Application No: Y/5/26/PL  
Site Address: 2 Downview Road Yapton BN18 0HS  
Description of works: Erection of terrace of 4 No town houses with gardens and parking spaces. This application is in CIL Zone 2 and is CIL Liable as new dwellings.

Thank you for your internet representation made on 10th March 2026 which has been recorded as an objection with the comments as follows:

2 Downview Road, Yapton : Proposed 4-unit 3-storey Terrace of 3-bedroom Dwellinghouses : PROPOSED SITE LAYOUT

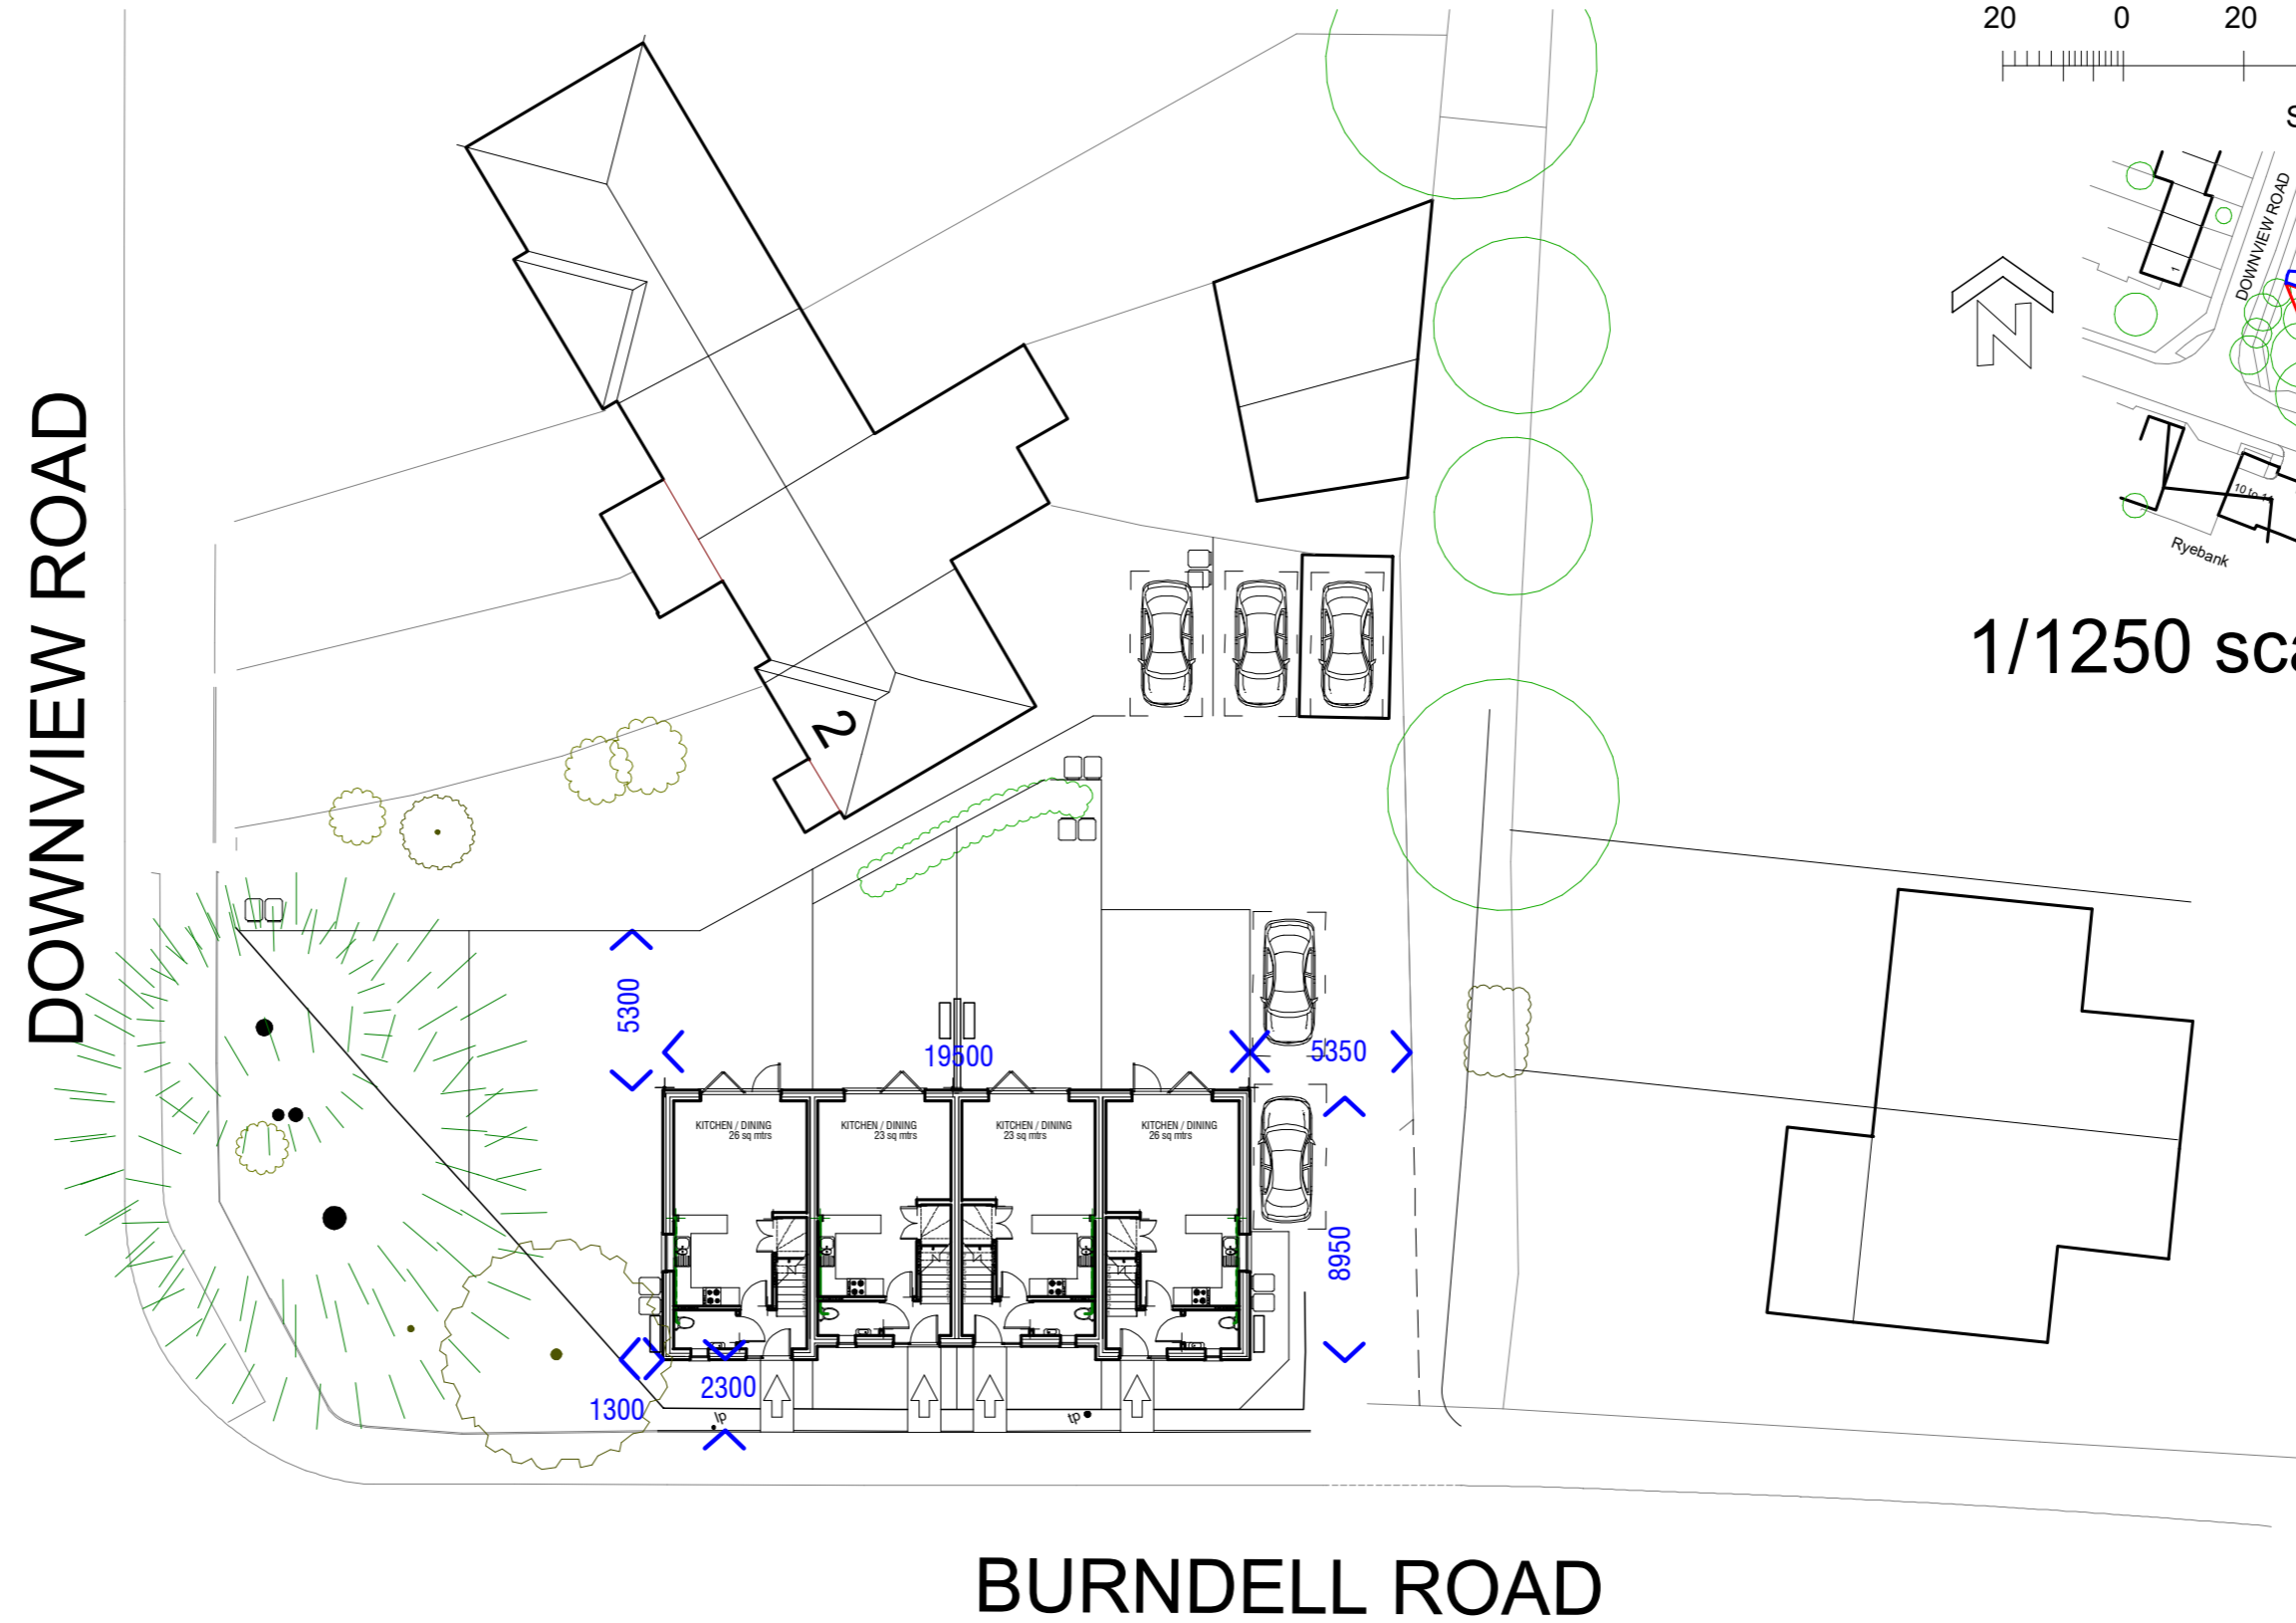
Due to all the new houses built in Yapton the main road (Burndell Rd) has become extremely busy. The proposed development is immediately opposite the entrance to the car park for Ryebank properties on the opposite side of the road. If built the houses would create a visibility problem for vehicles coming out of Downview Rd. As most households have two cars there will be a problem of parking. In Downview Rd we already have people living in Barndell Rd/Main Rd parking in our road causing us to have problems finding somewhere to park, so we don't want more cars fighting for parking. I cannot see how one could fit four houses in within the property boundary. The owners have already appeared to breach regulations by putting a two metre high fence alongside the footpath of Burndell Rd.
